## Report of the Head of Planning, Sport and Green Spaces

**Address** UNION HOUSE 23 CLAYTON ROAD HAYES

**Development:** Change of use of offices (Class B1a) to form 46 residential units (Prior Approval)

**LBH Ref Nos:** 35250/APP/2014/3506

PROPOSED FLOOR PLAN - LEVEL 0

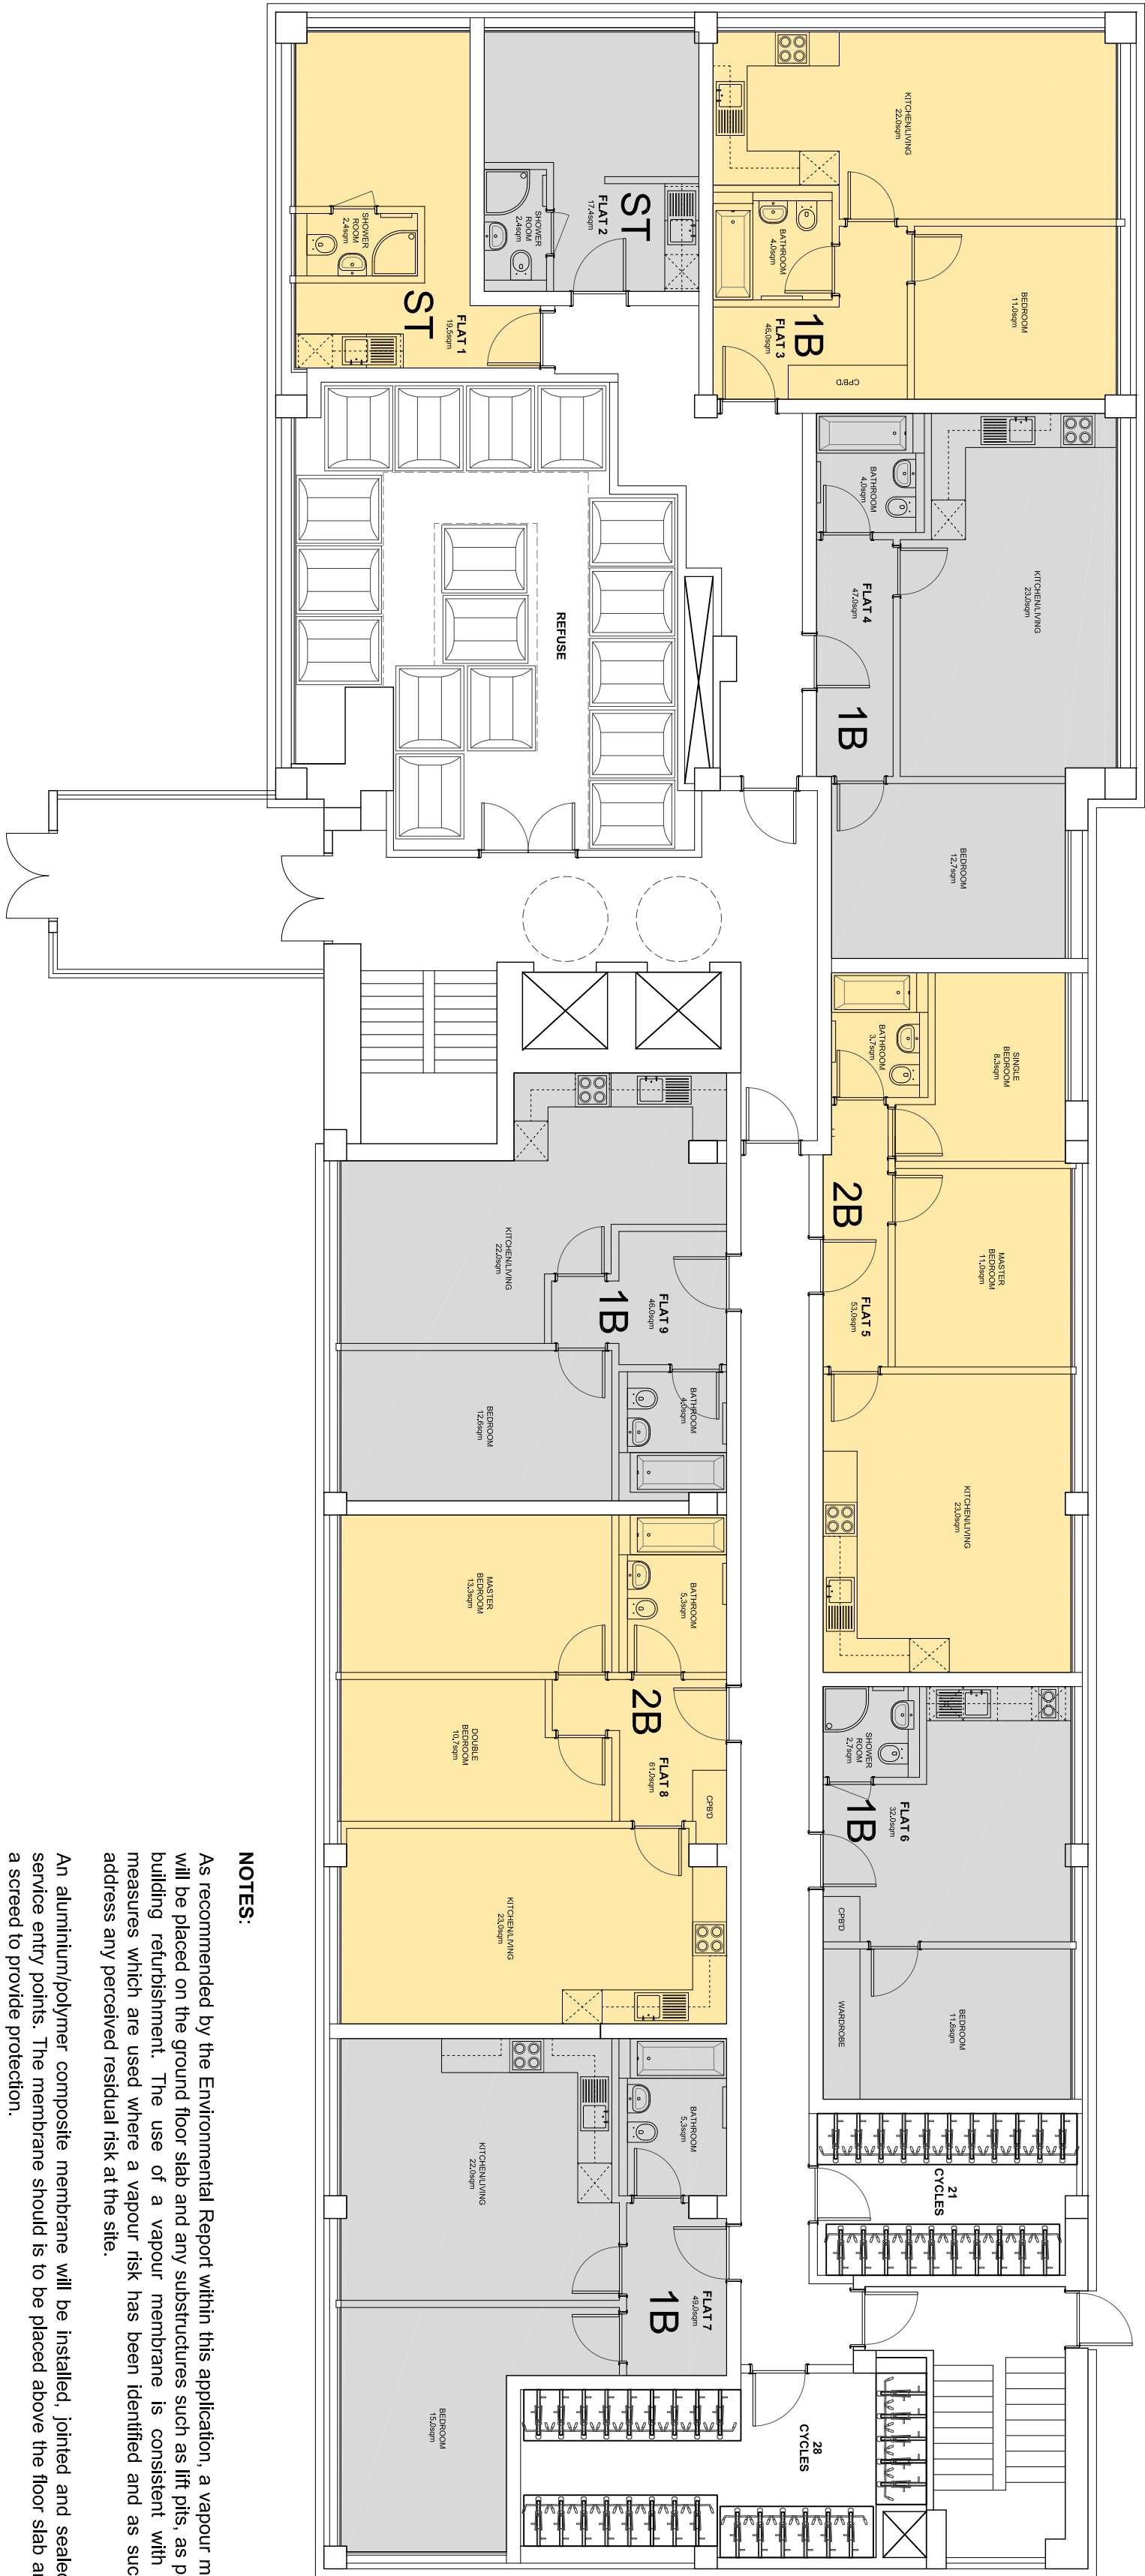
The Council's EPU (Land Contamination) Officer advises that there is insufficient information with regard to land contamination more specifically that no ground investigations were carried out or are proposed to be carried out prior approval is granted.

The possible risks identified by the EPU officer within the Phase I report include gas and vapour intrusion and require further investigation. No information has been provided with regard to the foundation design at the site. Gas and vapour intrusion from a soil and/or groundwater source and a lack of information on the foundation design is of particular

concern as the ground floor is indicated to be occupied by residential flats.

I do not have any objections in principle to the proposed development, however some ground investigation needs to be undertaken of the existing areas of soft landscaping in the location of ground gas and groundwater assessment boreholes to determine if any remedial actions are necessary to make the site suitable for the proposed use.

The internal car parking layout should be amended to provide a dedicated pedestrian path

and the access should have 2.4mx2.4m pedestrian visibility splays.

(1) The development shall not be occupied until full details of the pedestrian paths within the site have been provided in a manner to be agreed in writing with the Local Planning Authority; and only the approved details shall be implemented. In addition, the details of the vehicular access shall include details of the pedestrian/vehicle visibility splays of 2.4 metres by 2.4 metres on each side of the access, the depth measured from the back of the footway and the widths outwards from the edges of the access and thereafter permanently retained; no fence, wall or other obstruction to visibility exceeding 0.6 metres in height above the surface of the adjoining highway shall be erected within the area of the pedestrian visibility splays. The pedestrian paths and visibility splays shall thereafter be permanently maintained.

(2) (i) The development hereby permitted shall not commence until a scheme to deal with contamination has been submitted in accordance with the Supplementary Planning Guidance Document on Land Contamination and approved by the Local Planning Authority (LPA). The scheme shall include all of the following measures unless the LPA dispenses with any such requirement specifically and in writing:
